18 May 2018

OUR REF: 476088 - 01000

**Re: 770 Brookfield Transportation Impact Assessment
Addendum #1**

Figure 9: Proposed Site Plan

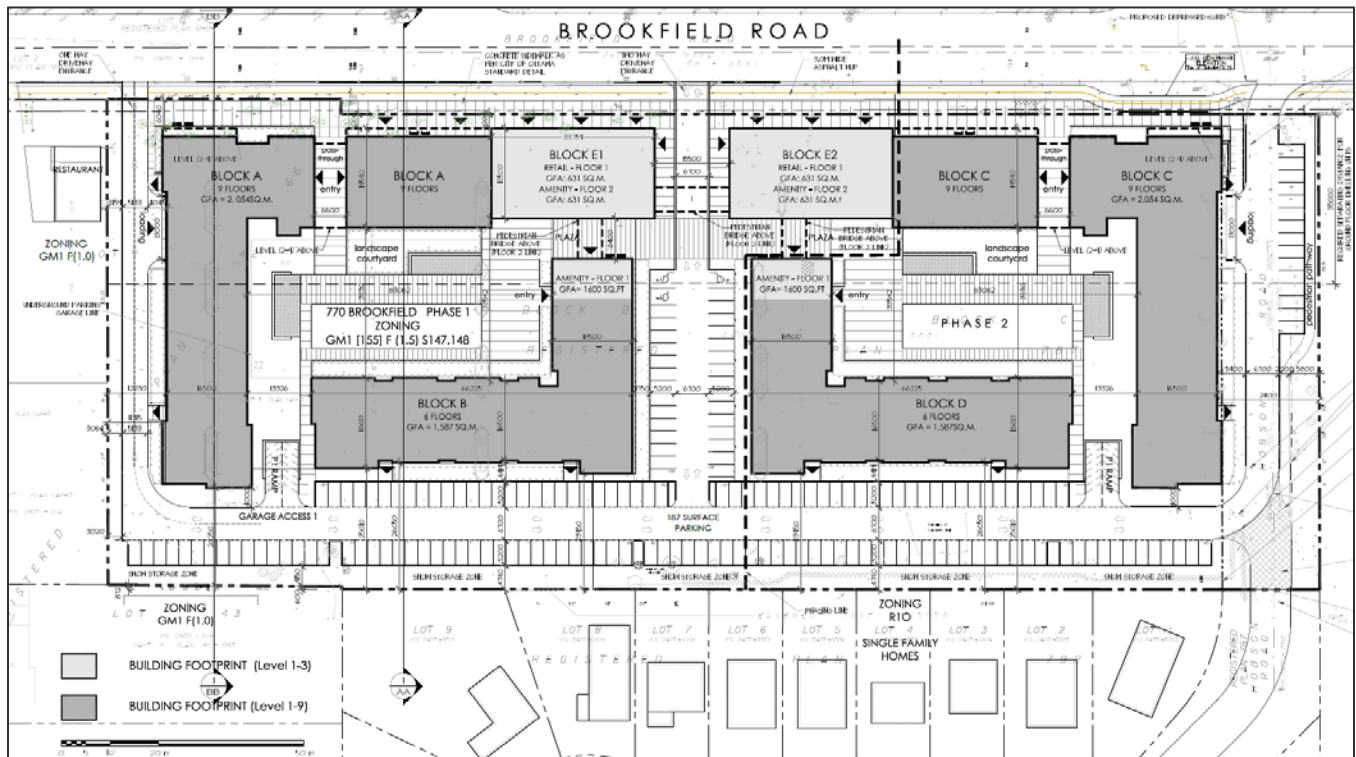
Comment 1: Brookfield Road is designated as an Arterial road within the City's Official Plan with a ROW protection of 26.0 metres. The ROW limits are to be shown on all the drawings and the offset distance (13.0 metres) to be dimensioned from the existing centerline of pavement.

Comment 5: *Curb returns are to be provided at the accesses with a minimum radius of 5.0 metres and are to be dimensioned on the drawings.*

Comment 6: *Ensure that the end of the curb return at the proposed driveway does not encroach within the frontage of the adjacent property.*

Comment 7: *Minimum lane width for fire trucks is 6.0 metres.*

Comment 12: *The existing hydrant is to be relocated to accommodate the width of the MUP and Buffer.*

Response 1: Noted and the architect has been advised.

Response 5: Noted and the architect has been advised.

Response 6: Noted and the architect has been advised.

Response 7: Noted and the architect has been advised.

Response 12: Noted and the architect has been advised.
